Permit #2304-163 Intake 1 Screening Response

Date May 1, 2023

From Allison Hogue
Floisand Studio

Reference Intake Comments CST dated 4/26/23

**A0.10\_1**

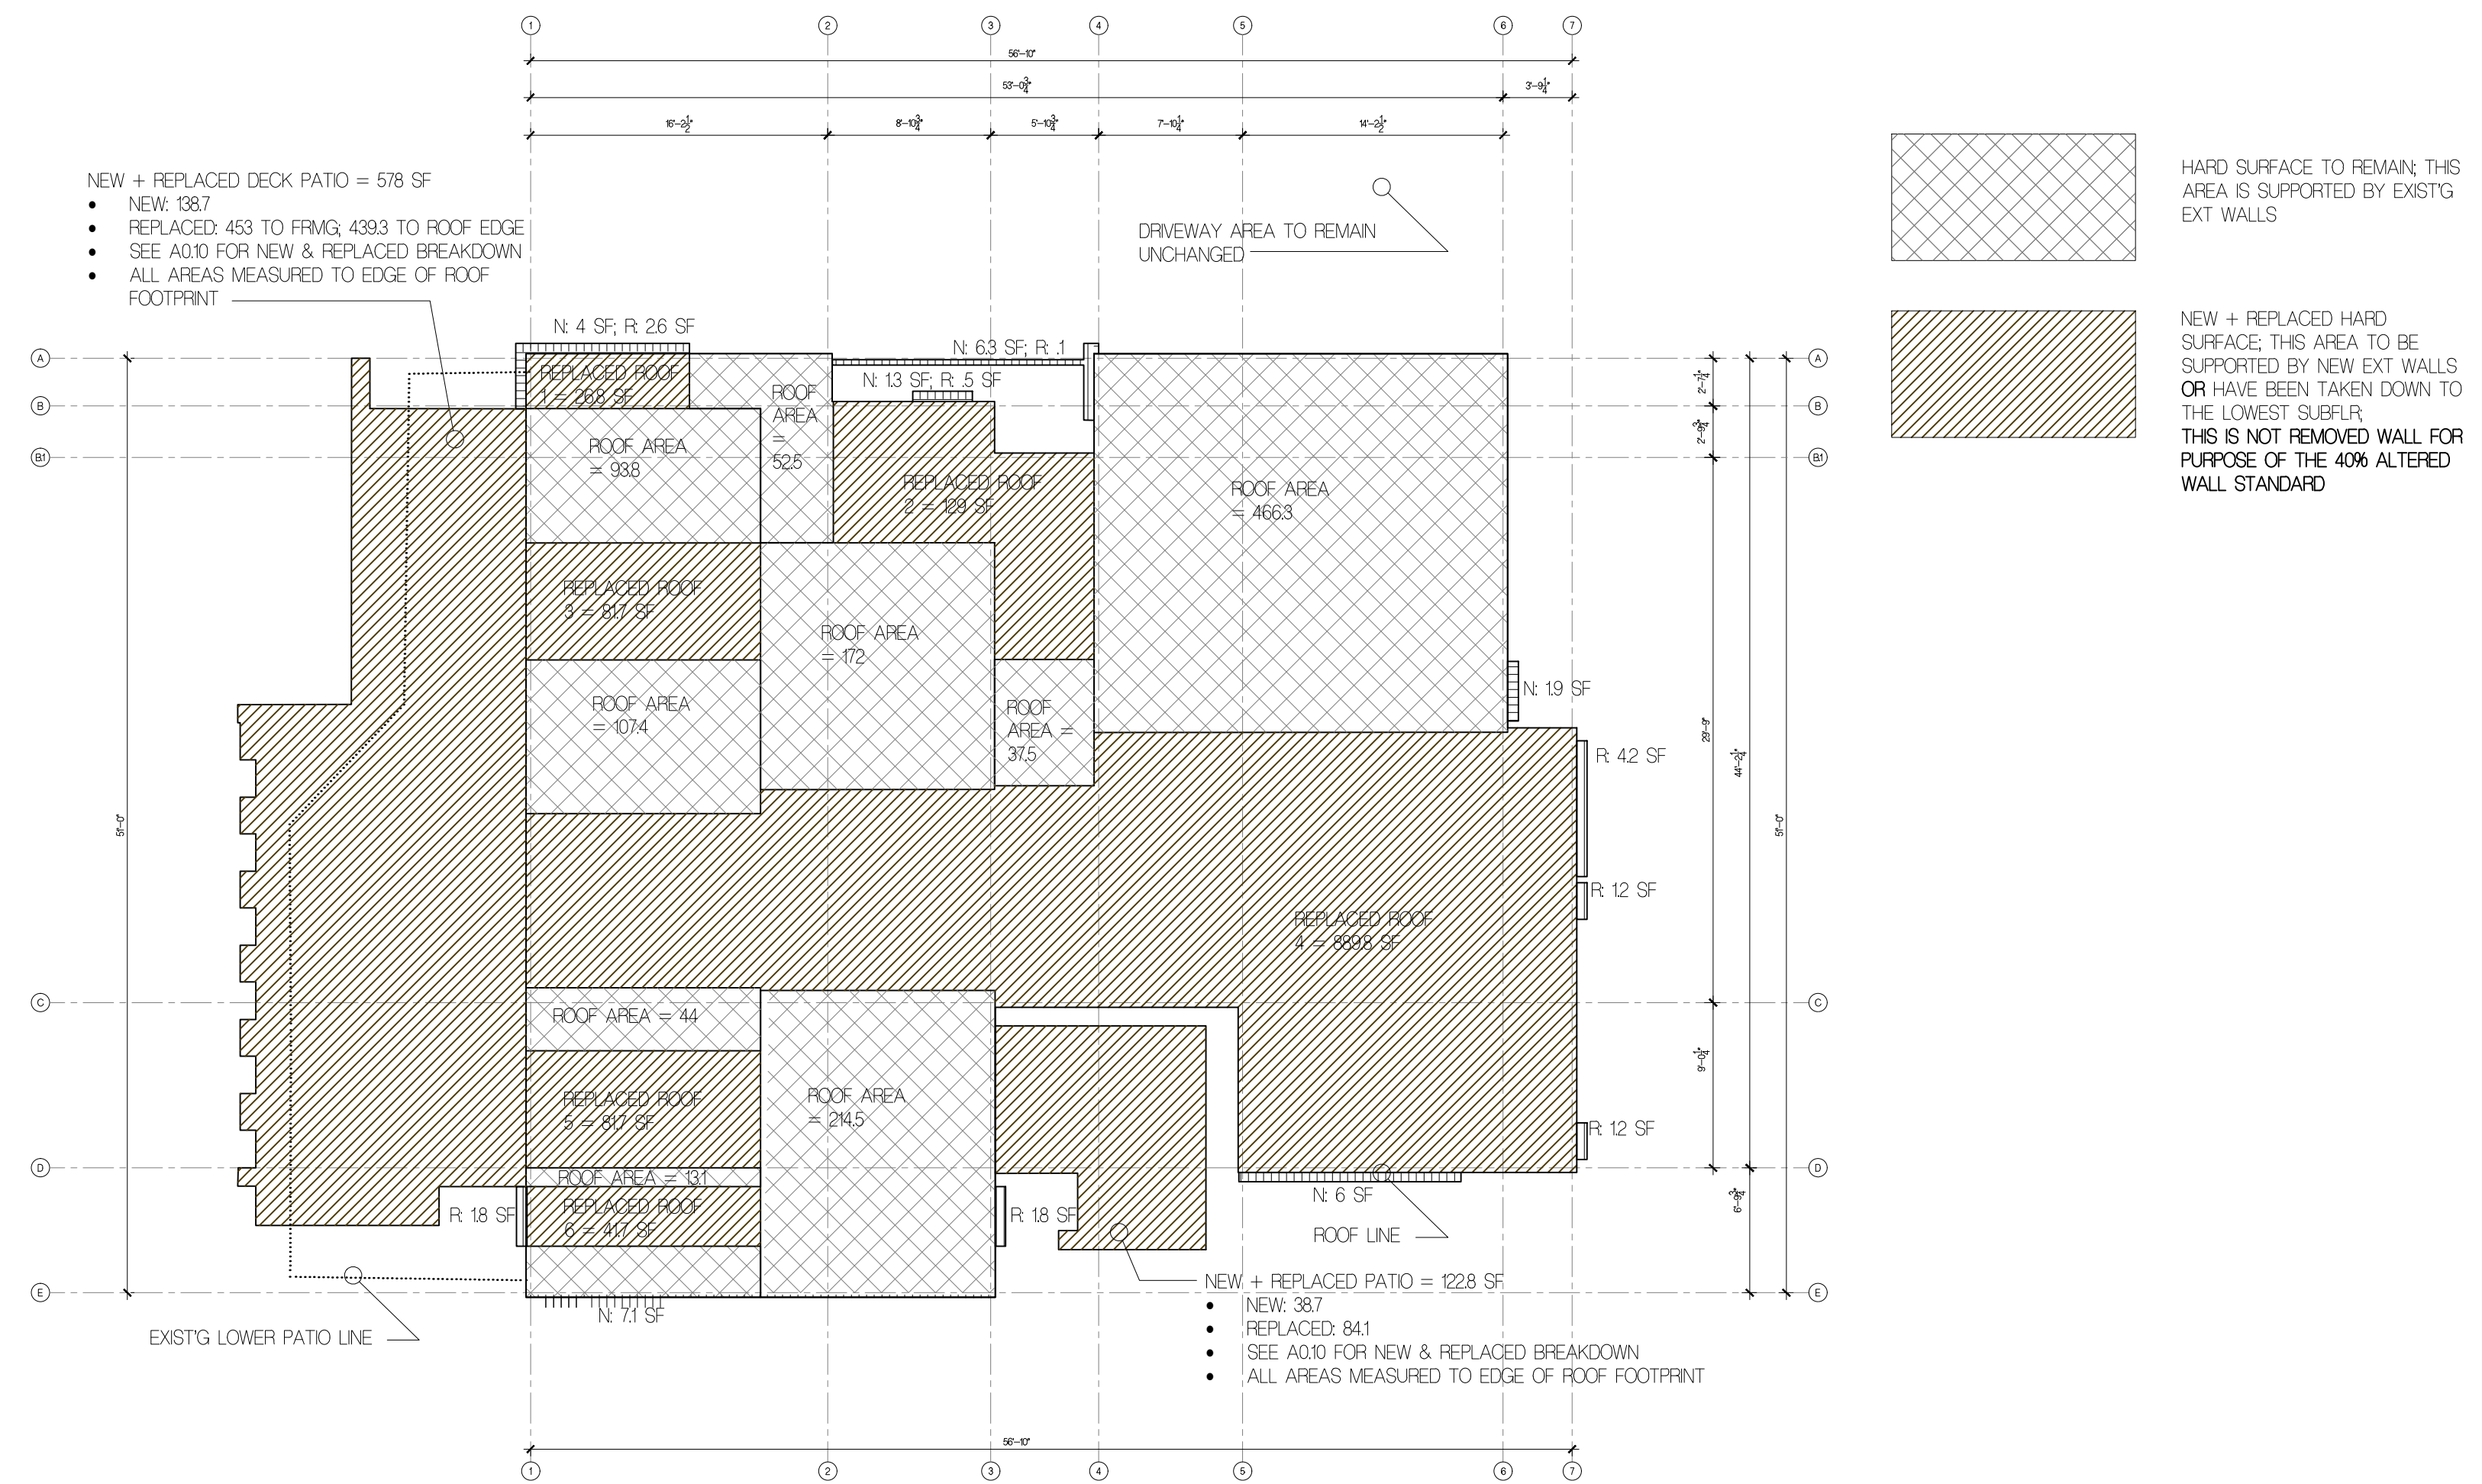
- Stormwater Design Requirements: Based on the criteria outlined in 15.09.050, the project does not meet the City's minimum requirements for stormwater management and therefore is not subject to review. Please refer to new sheet A0.10_1 for a diagram and calculation outlining New Plus Replaced Hard Surface Area. The project will result in less than 2000 SF of new plus replaced hard surface. See A0.10 for the Impervious Surface diagram and calculation. The project will result in a net decrease of impervious surface. The project also will not result in land disturbing activity of 7,000 SF or greater.
